From: Anita Gardner <Anita.Gardner@arun.gov.uk>
Sent: 05 June 2020 14:23
To: Planning.Responses <Planning.Responses@arun.gov.uk>
Subject: FW: A/25/20/DOC - Arundel Rd - Additional Info - Updated AMS

Regarding the drainage DOC, See attached my last email to the applicants engineer. Some items have been dealt with but the outstanding ones I believe are; items 11,24, 29 and 30.

From: Paul Cann
Sent: 16 April 2020 15:50
To: Chris Slade
Cc: Luke Honeywill; James Elsey; Sarah Burrow; Kevin Macknay
Subject: RE: A/144/19/DOC Land East of New Place Nursery, Arundel Road, Angmering

Subject: RE: A/144/19/DOC Land East of New Place Nursery, Arundel Road, Angmering

Attenuation tank using polystorm-r geomodular units

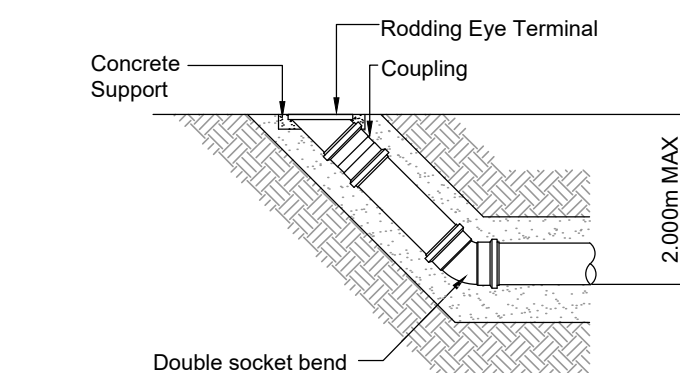
14. Provide manhole as close to the tank as possible on incoming pipe and provided the vented cover at this location rather than the one shown at S5. Manhole to also include a sump. Show ventilation link pipe on plan. Also alter construction details to suit this arrangement - Done

20. Geosynthetic encapsulating polystorm unit – provide technical brochure extract detailing the tanking spec - Attached.
21. Add general note regarding manhole cover grades ie. grade and use - Done

Typical fin drain outlet from porous surfaces

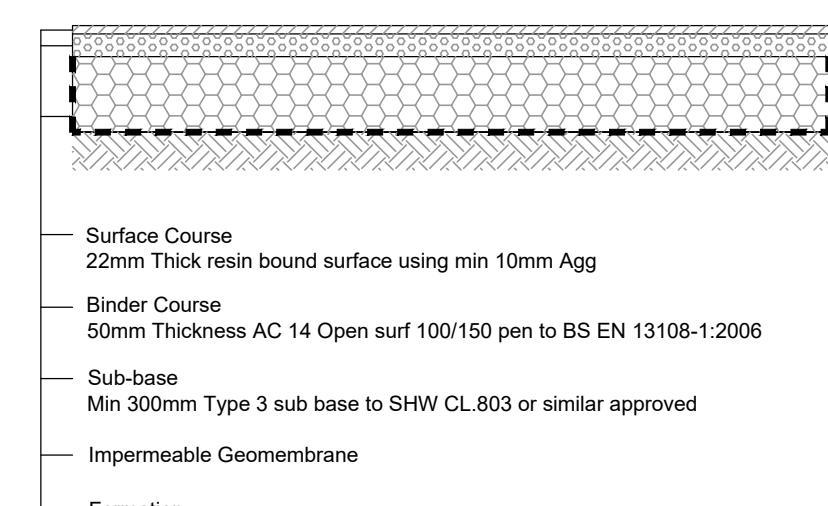
25. Driveways are falling towards the properties. Whilst the sub base water is being collected by fin drains, additional measures need to be put in place to protect the property/garages should the permeable surface become blinded and ineffective. I would suggest a decent channel drain - Agreed. Channel drain added.
